Date: 10-Oct-2025
Our Ref: 2025/92559

**Application for a non-material amendment following a grant of planning permission,
Town and Country Planning Act 1990**

**Non material amendment to previous permission 2024/91367 for external recladding
of the building and installation of fire suppression sprinkler tank in grounds
Buckden Court, Chesil Bank, Quarmby, Huddersfield, HD3 4EB
Application Number: 2025/92559**

Chesterfield 01246 233 235	Cambridge 01223 838 100	Leeds 0113 512 7510
Scale 1:100@A1	Drawn/Checked AM	
Job Number 23042	Date 04/06/24	
Drawing Number 23042-FSA-BC-ZZ-DR-A-2004	Rev P02

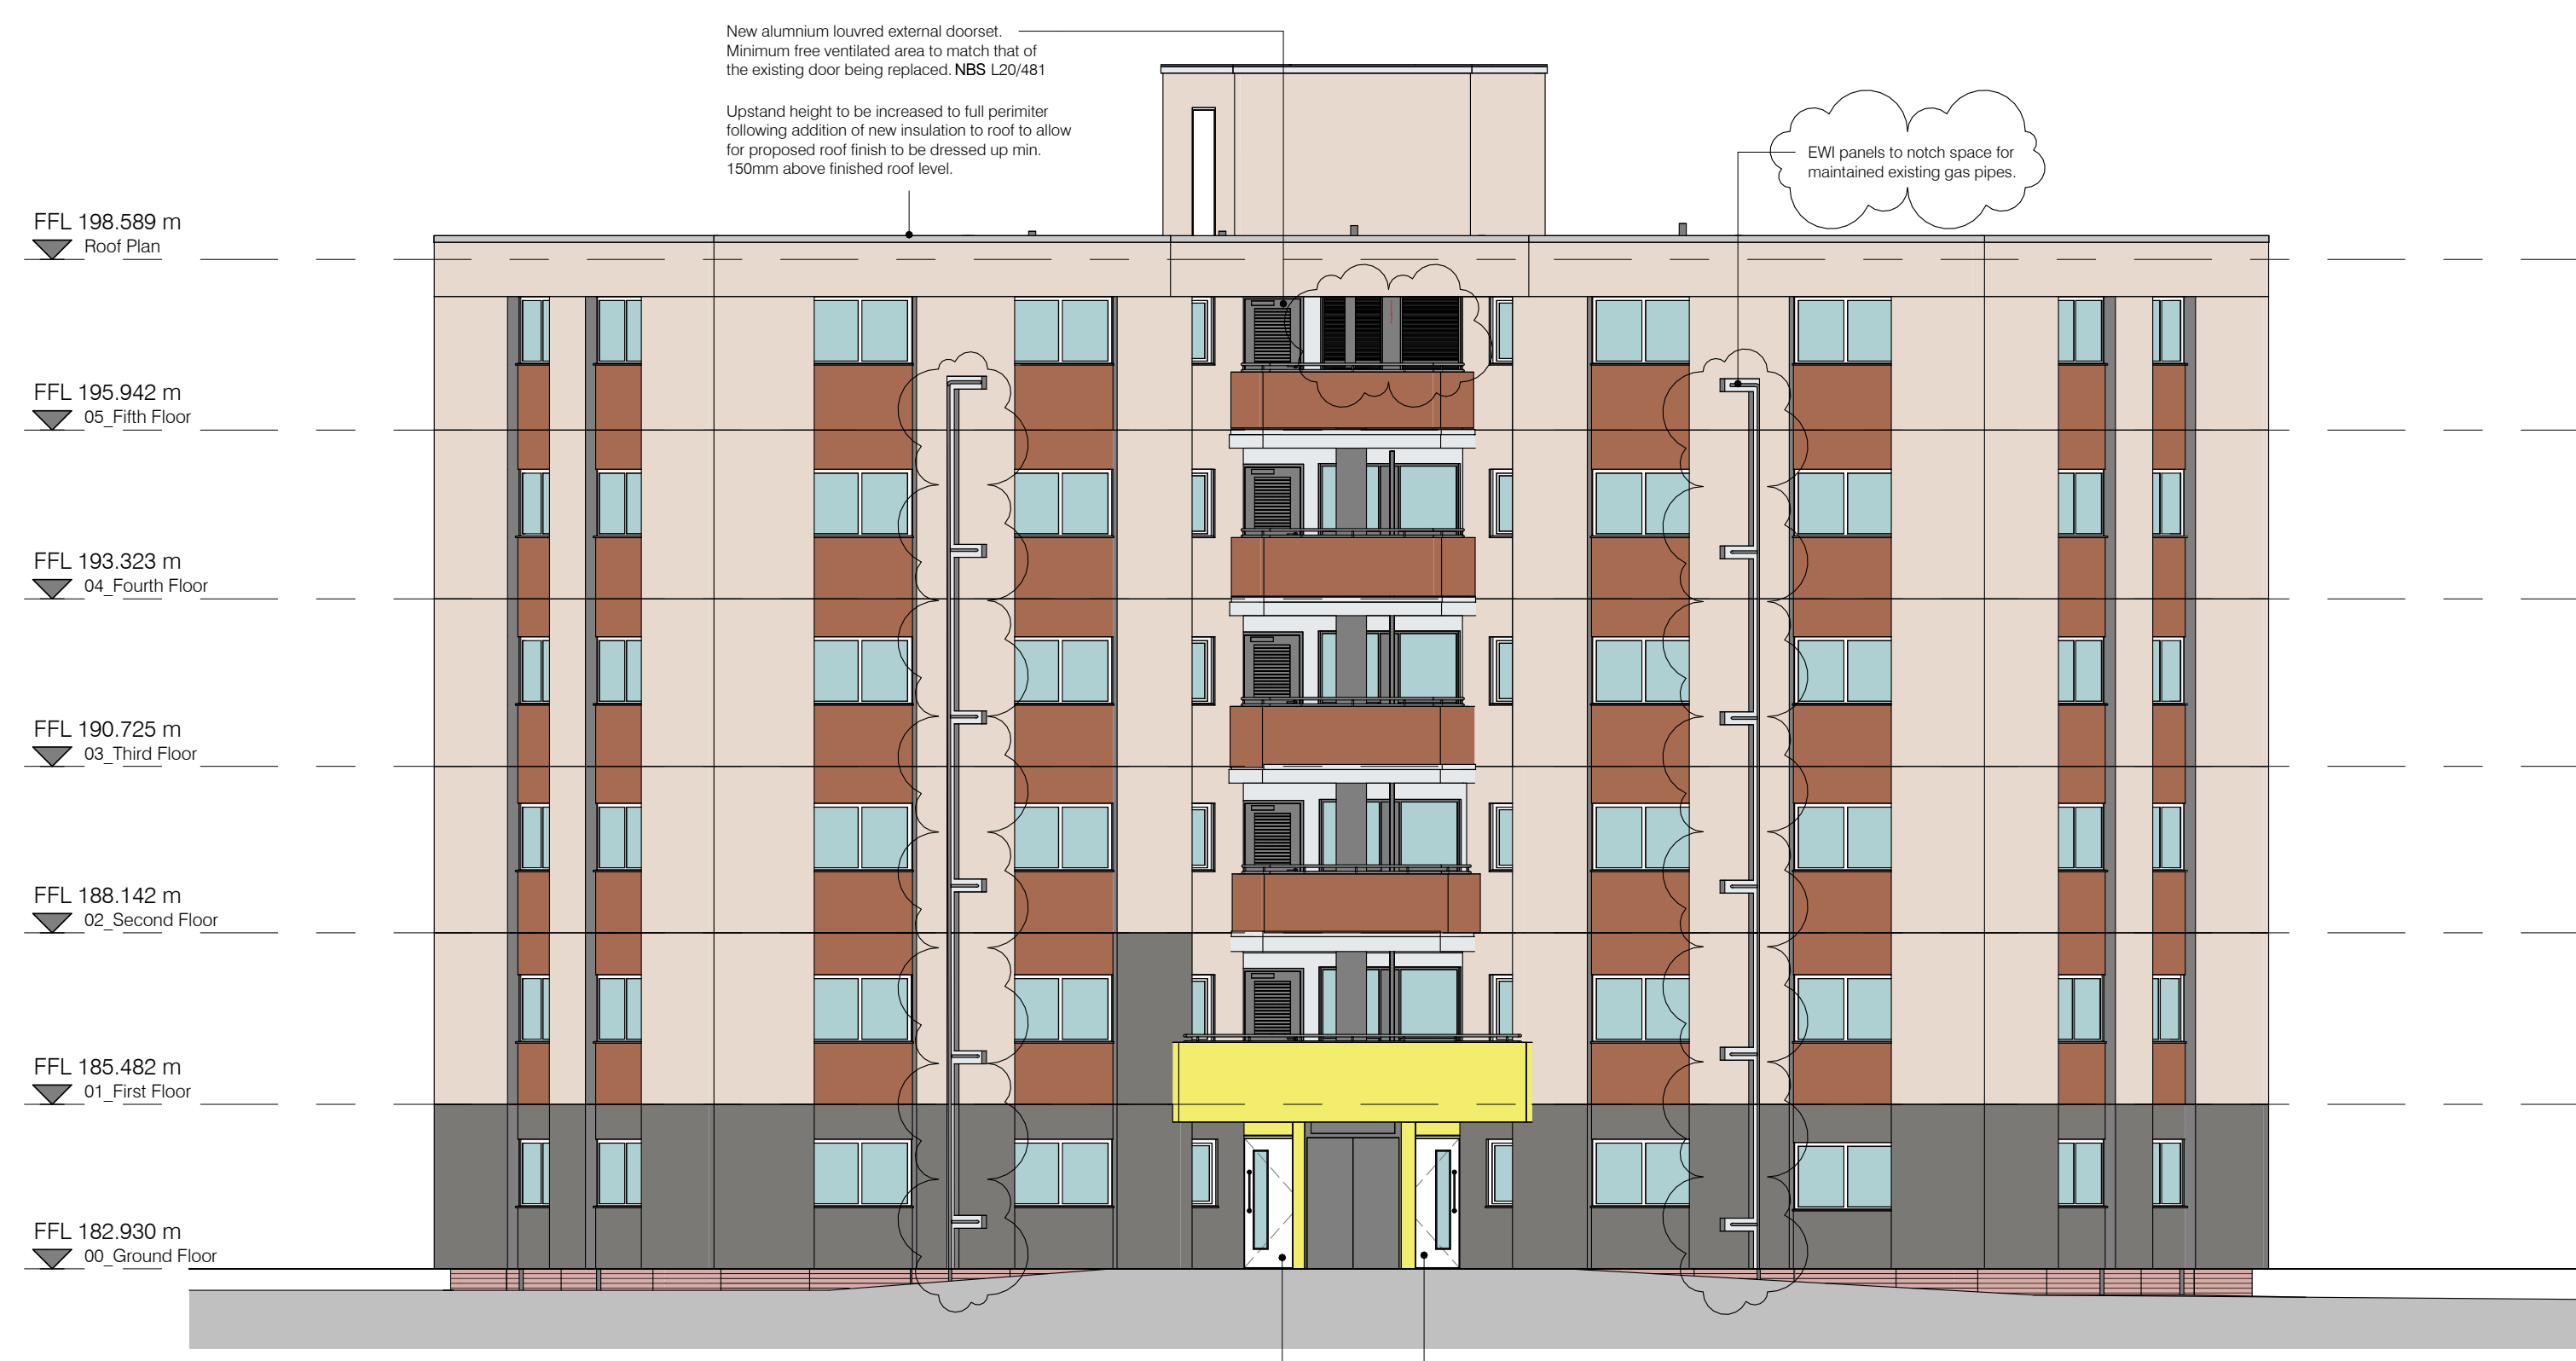
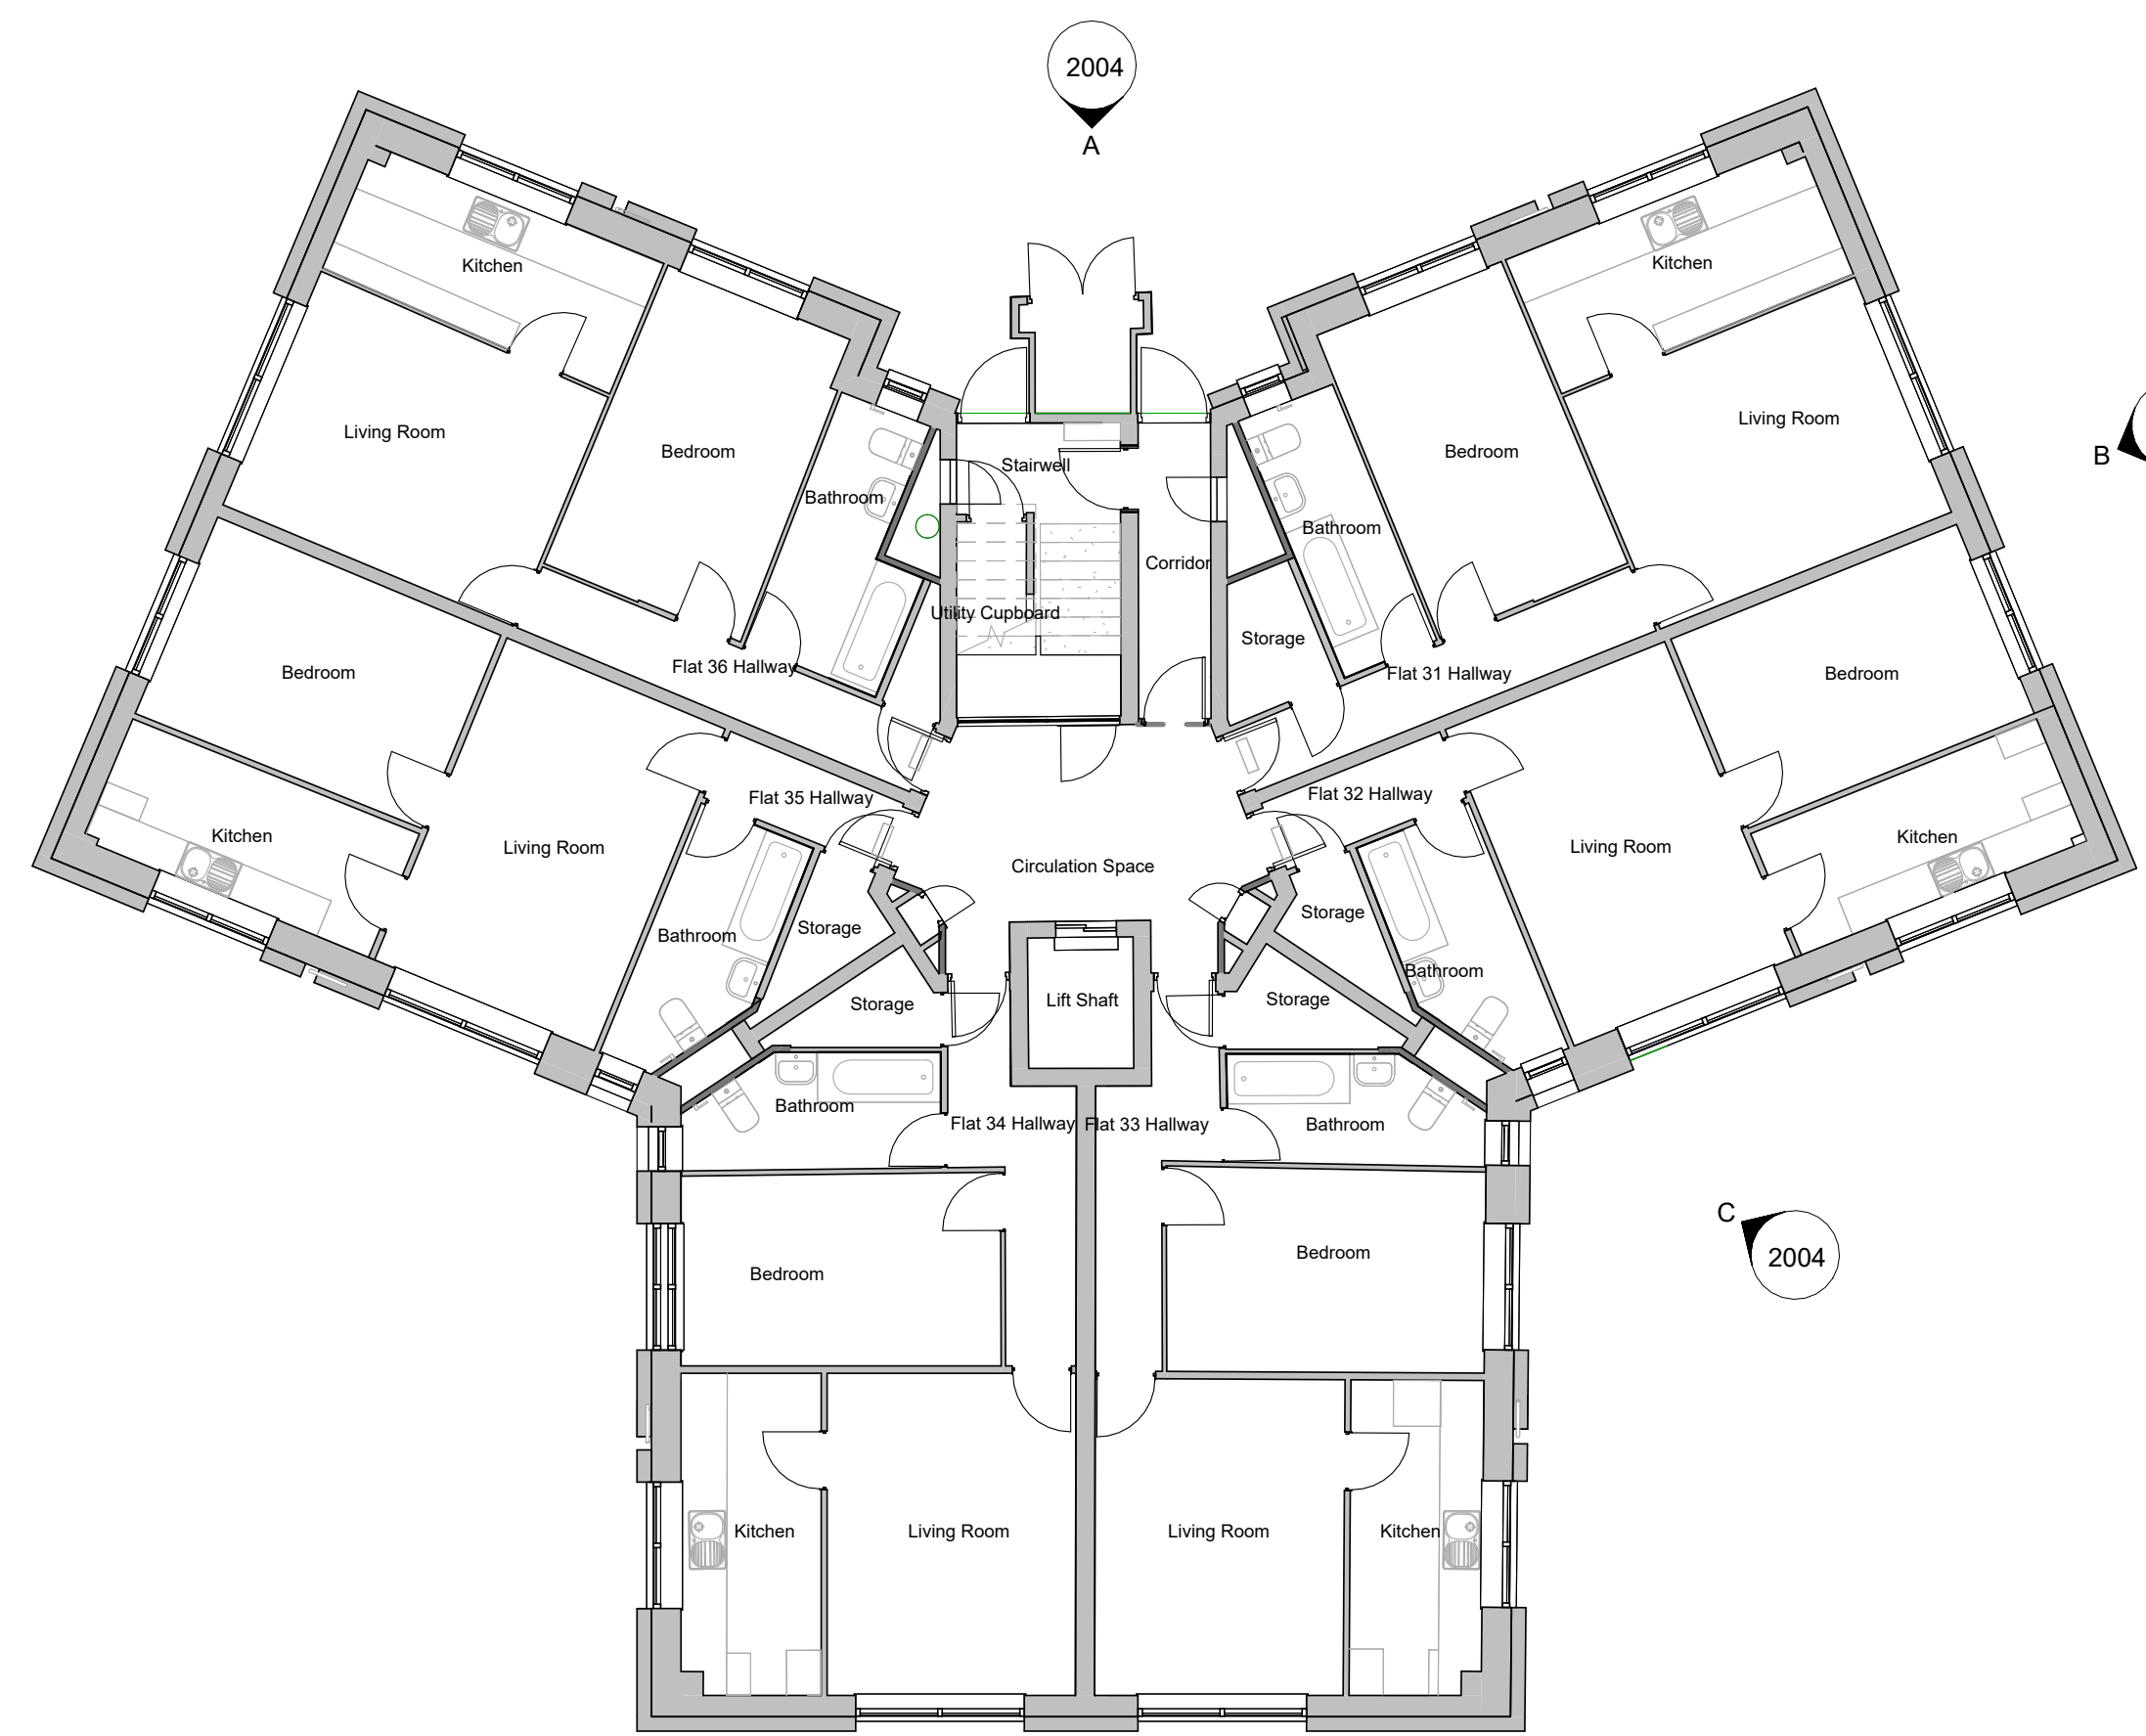
- Space between panels to retain the gas pipes as existing on 6 no. elevations

- Proposed elevations sheet 1 of 2 reference: 23042-FSA-BC-ZZ-DR-A-2004
Rev P02
- Proposed elevations sheet 2 of 2 reference: 23042-FSA-BC-ZZ-DR-A-2005
Rev P02

I confirm that the alterations are acceptable as a non-material amendment to the approved
drawing(s) and are hereby approved.
